**From:** Jennifer Ballinger <Jennifer.Ballinger@Cherwell-DC.gov.uk>  
**Sent:** 15 May 2020 13:50  
**To:** Gemma Magnuson <Gemma.Magnuson@cherwell-dc.gov.uk>  
**Subject:** Cedar Lodge - 20/00845/DISC

Thank you for consulting the Conservation and Design Team on the above application. The following conditions relate to the works to the potting shed only.

# CONSERVATION CASEMENT

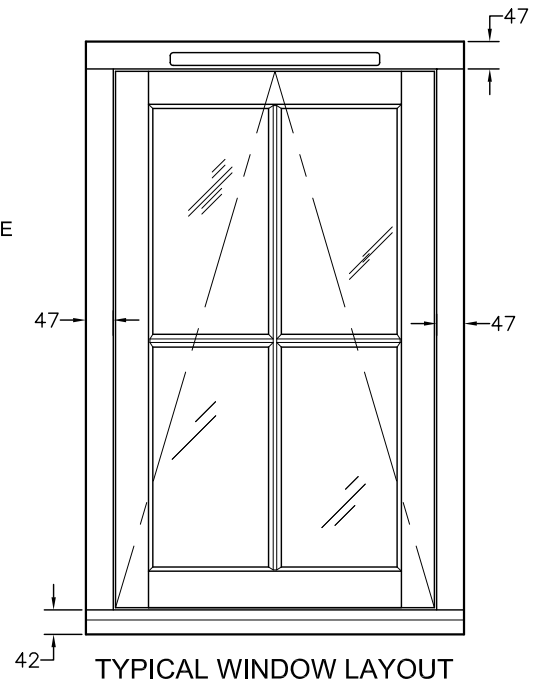
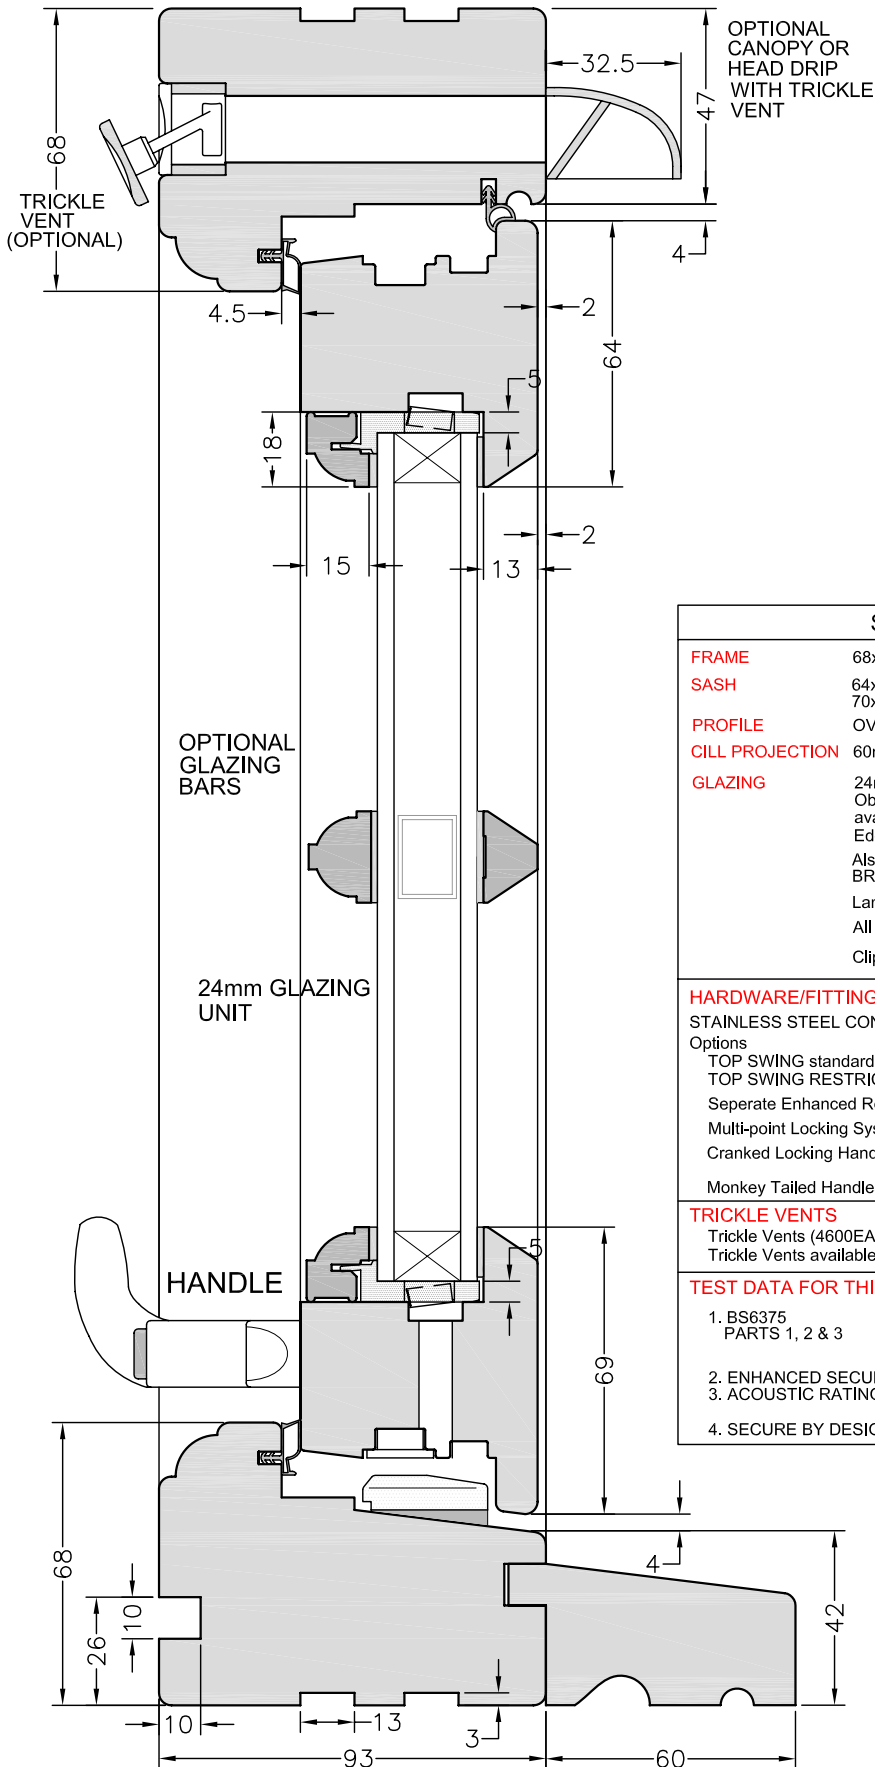
It is unclear why details of the windows have been submitted as there is no condition for windows. There are remaining concerns that the windows match those on the principal property. There are remaining concerns that the windows are not suitable as they are standard double glazed with applied glazing bars.
